WEST SUSSEX COUNTY COUNCIL CONSULTATION

TO:	Arun District Council FAO:Mr S Davis
FROM:	WSCC - Highways Authority
DATE:	29 July 2019
LOCATION:	Rear of Inglenook Hotel 253-255 Pagham Road Bognor Regis PO21 3QB
SUBJECT:	P/58/19/PL Erection of 9 No. dwellings with associated access, parking, cycle & refuse storage & landscape design. This application is a Departure from the Development Plan & may affect the setting of a listed buiding.
DATE OF SITE VISIT:	N/A
RECOMMENDATION:	More Information
S106 CONTRIBUTION TOTAL:	£ See below for breakdown.

Visibility Splays and Internal Swept Path Analysis

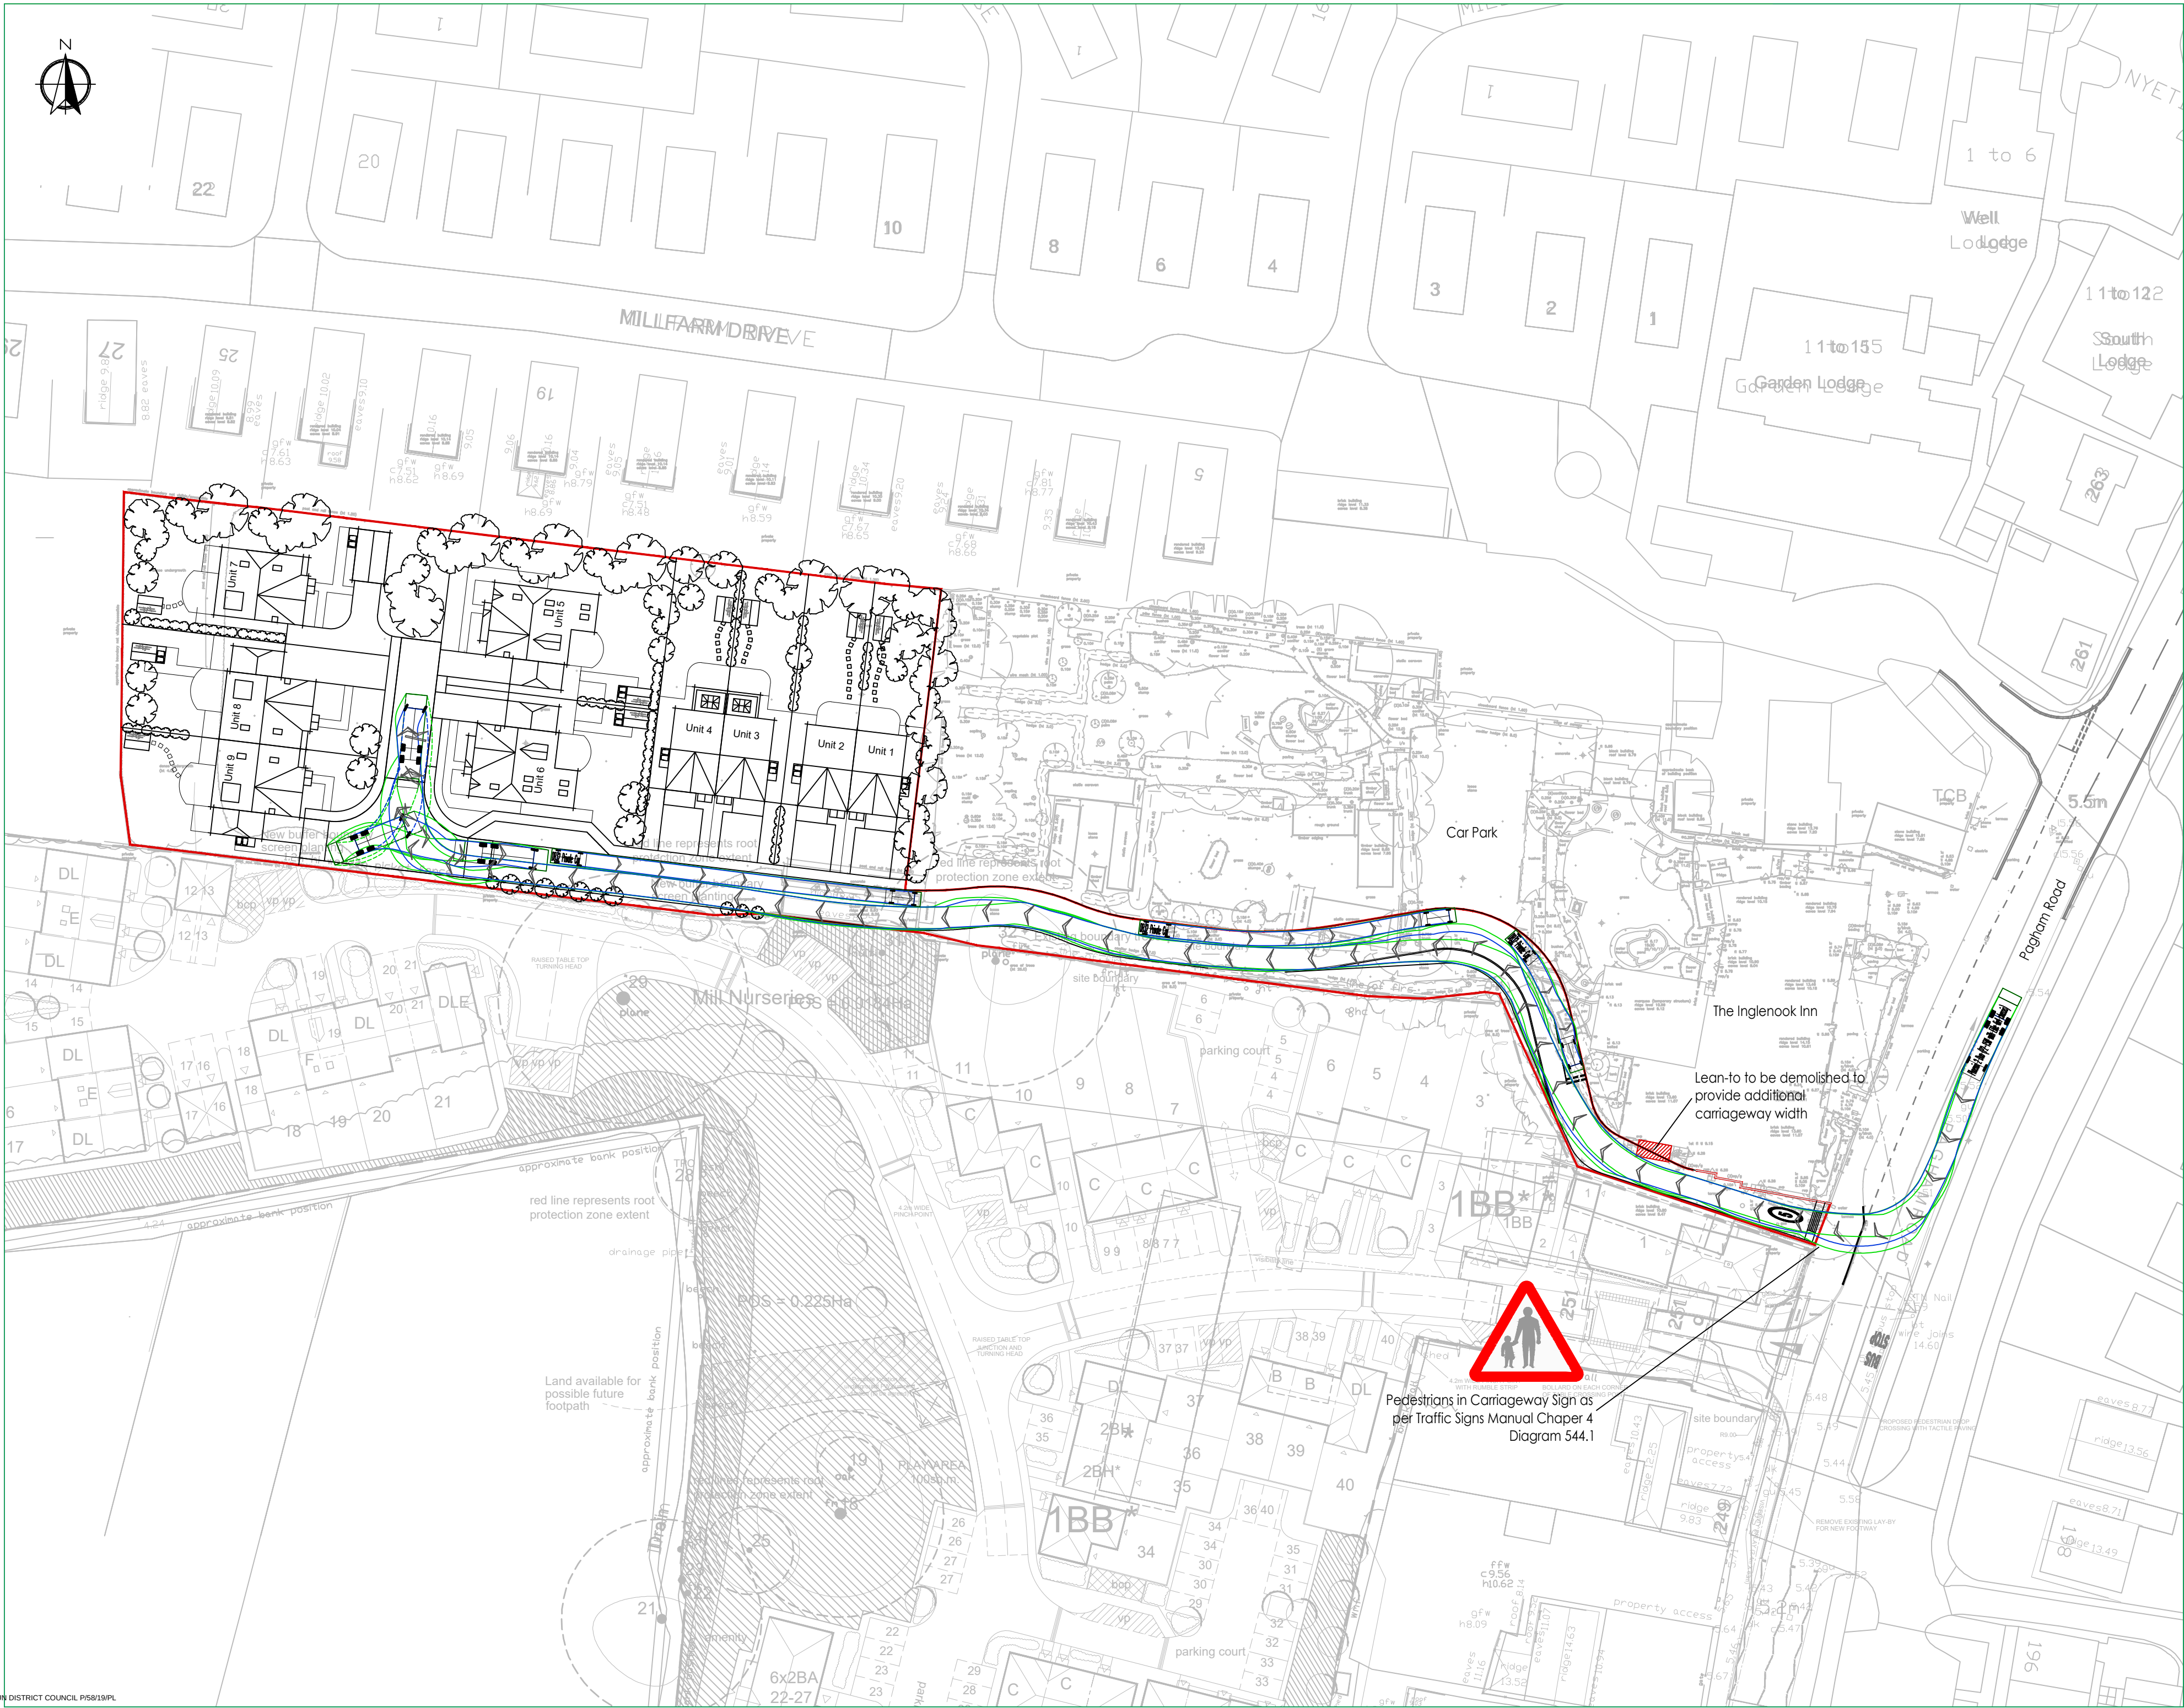
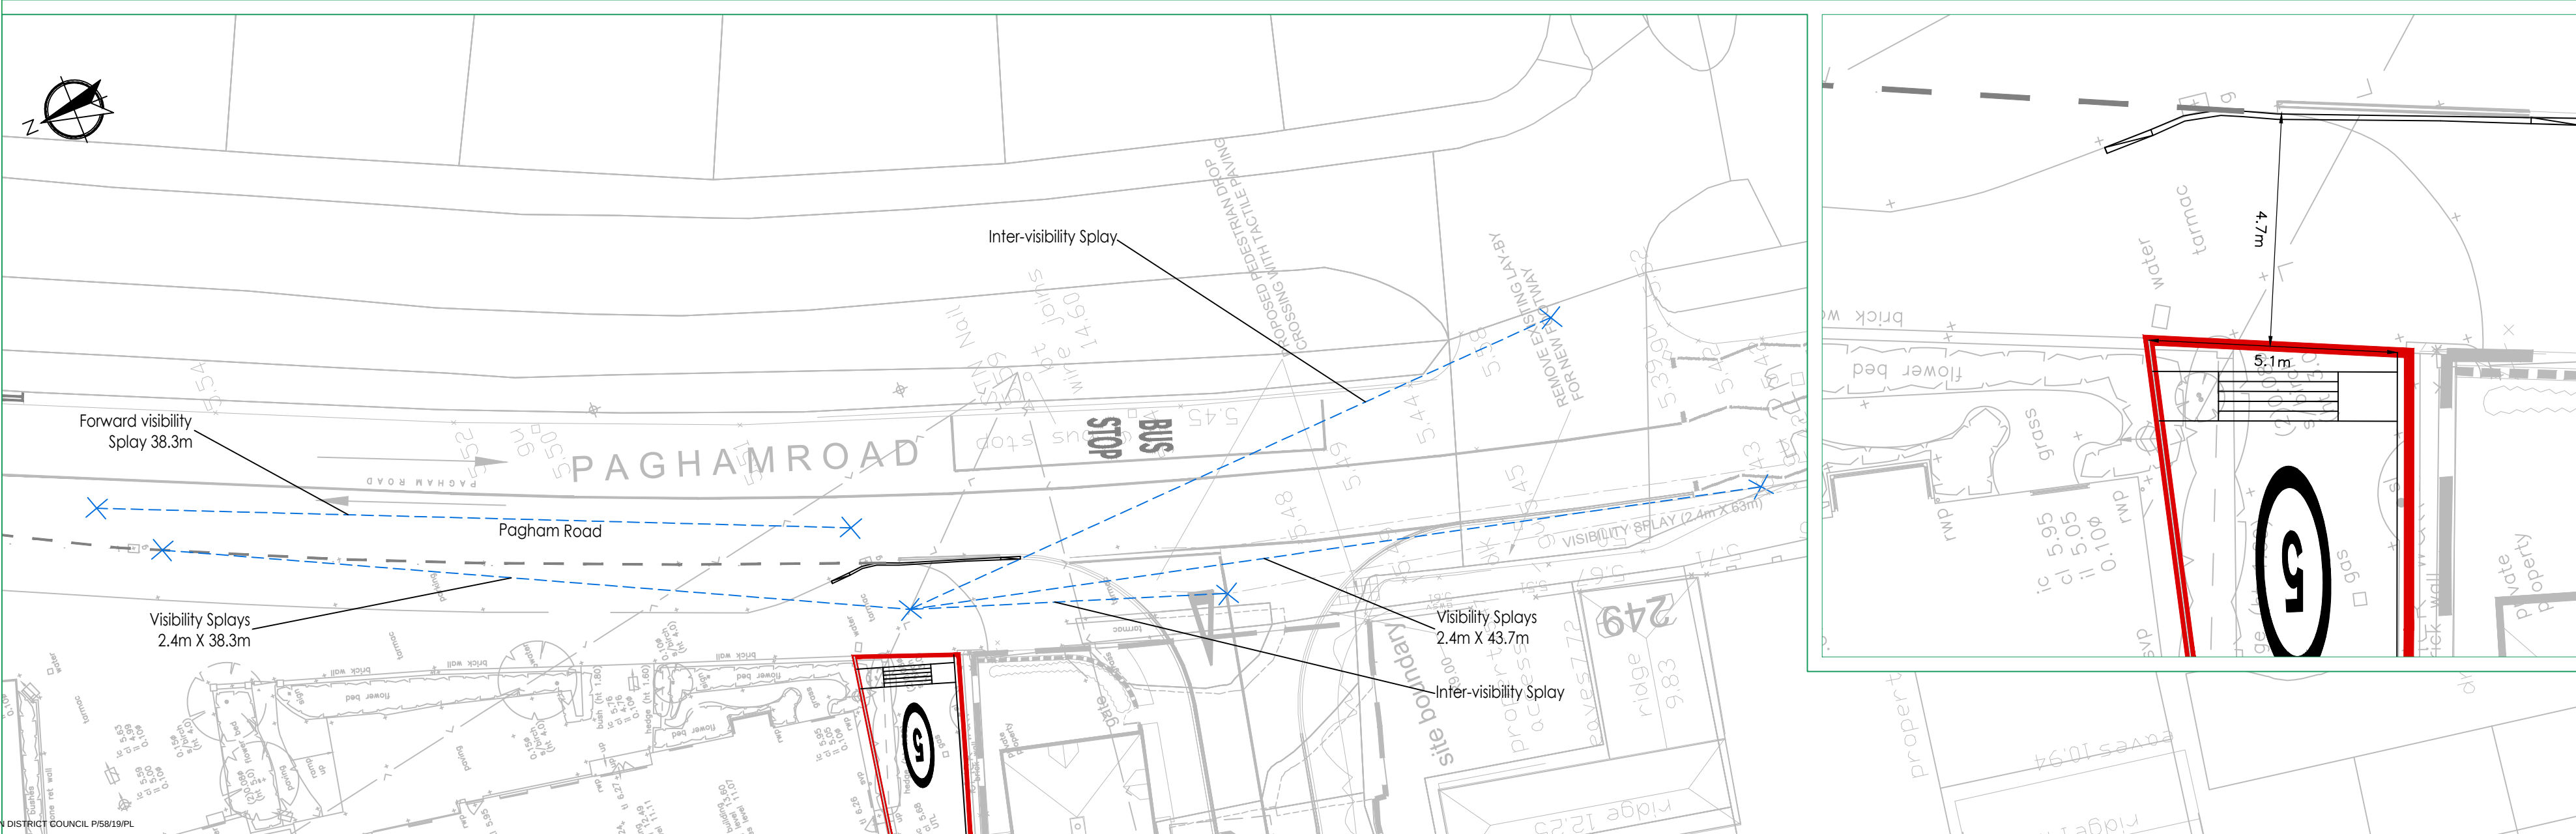
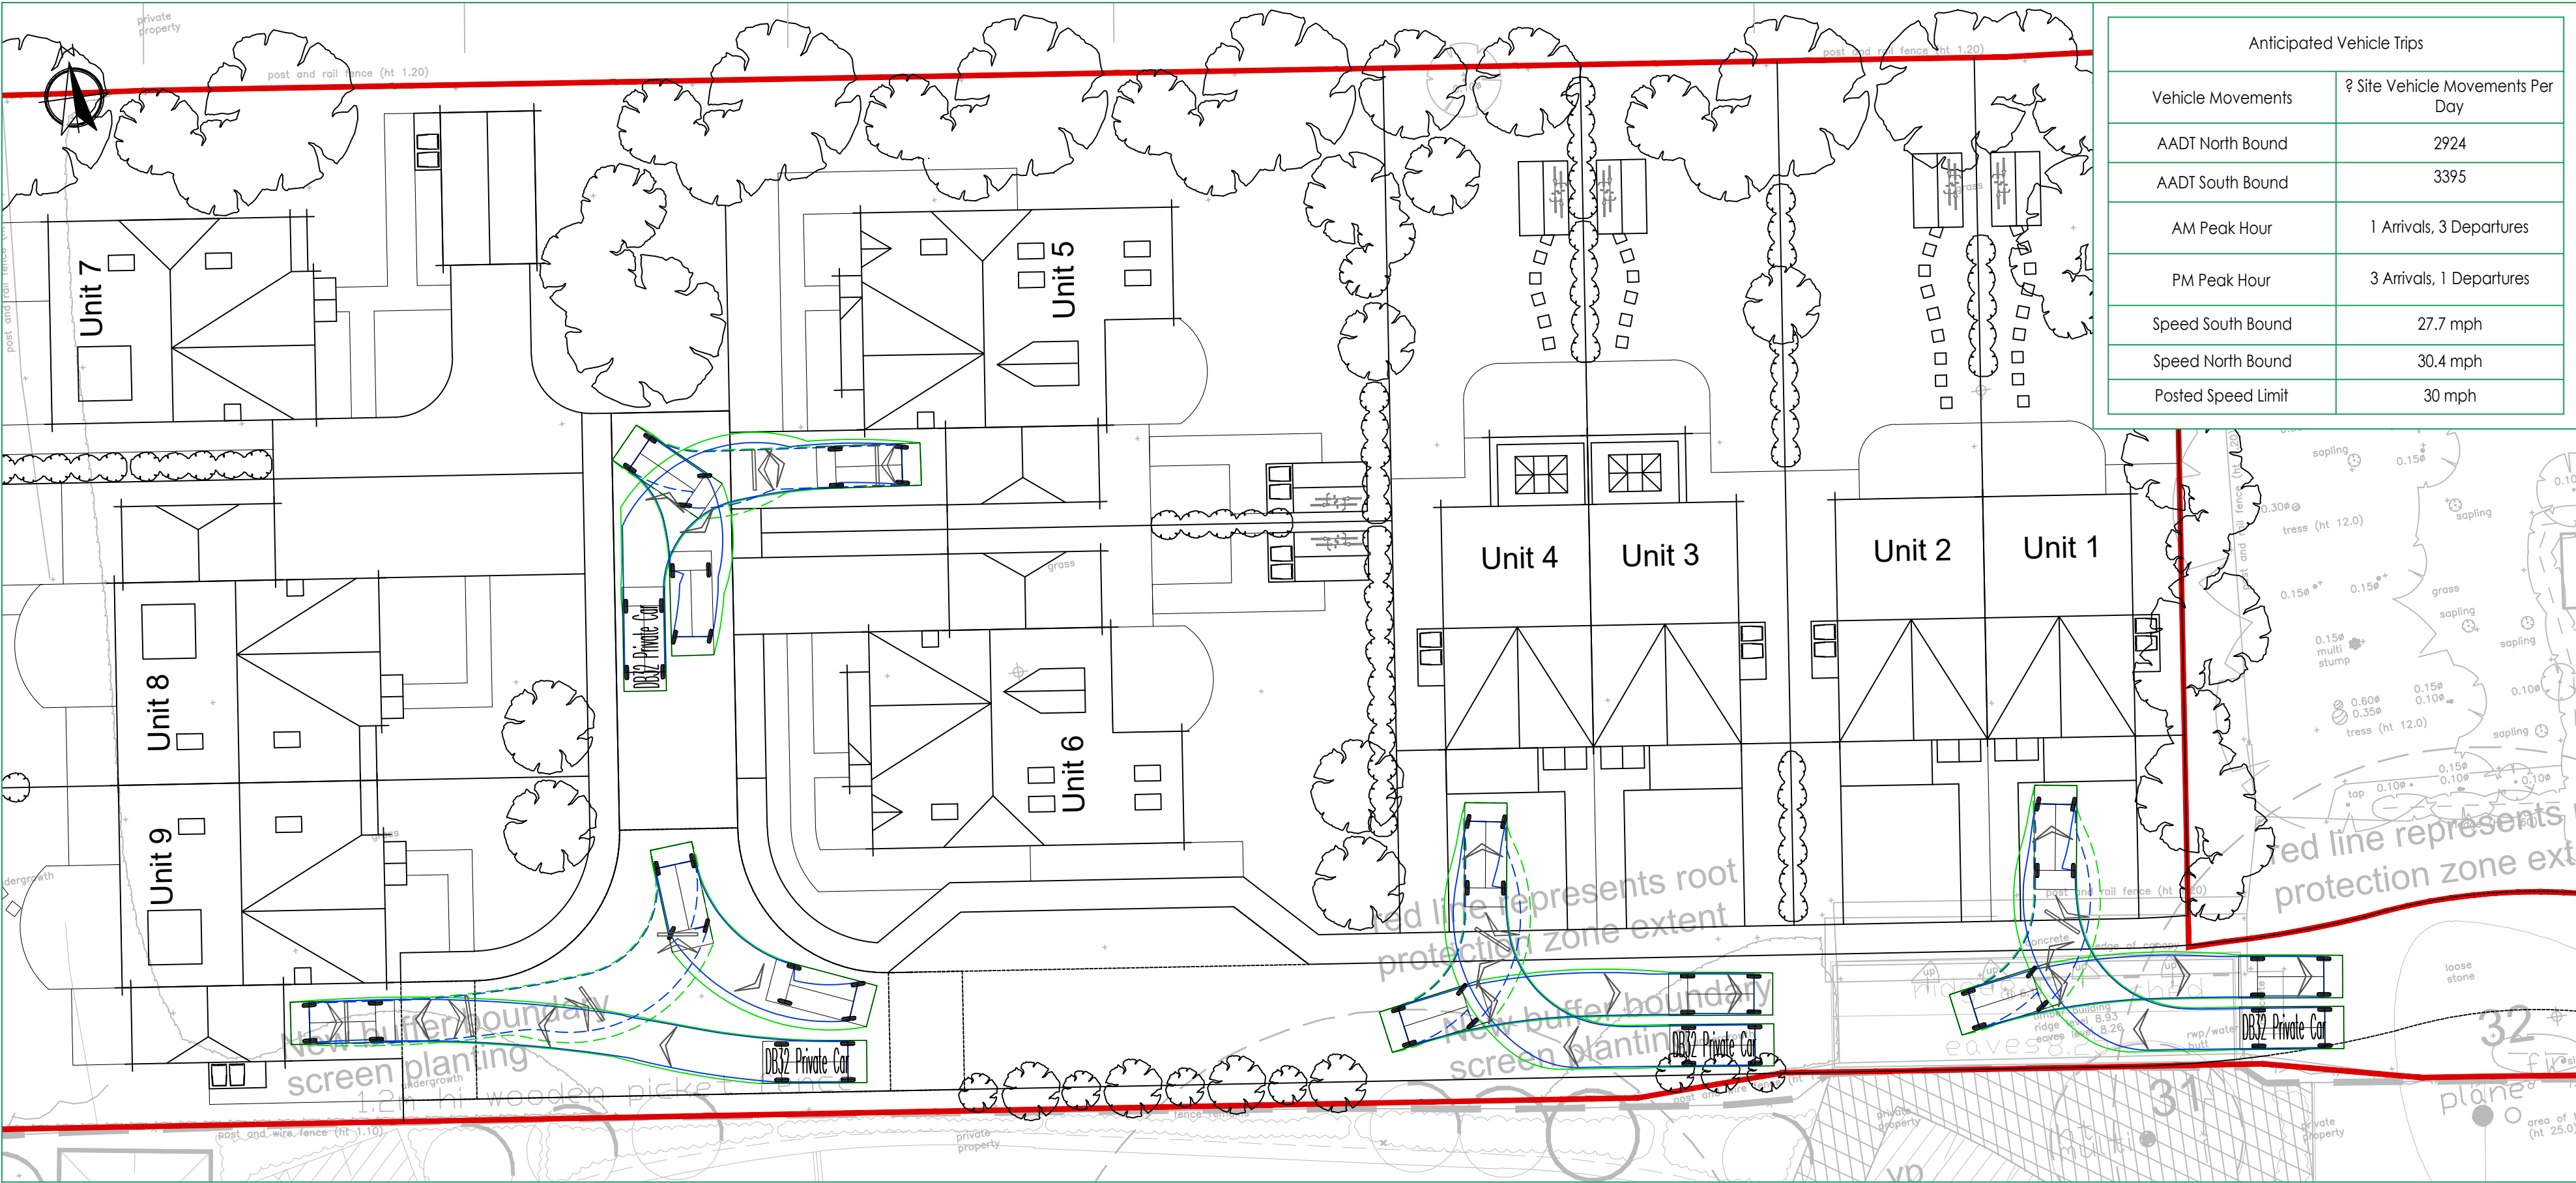
I have consulted the Area Highway Manager regarding the proposed signage and can advise that the Pedestrian in Carriageway sign is not required.
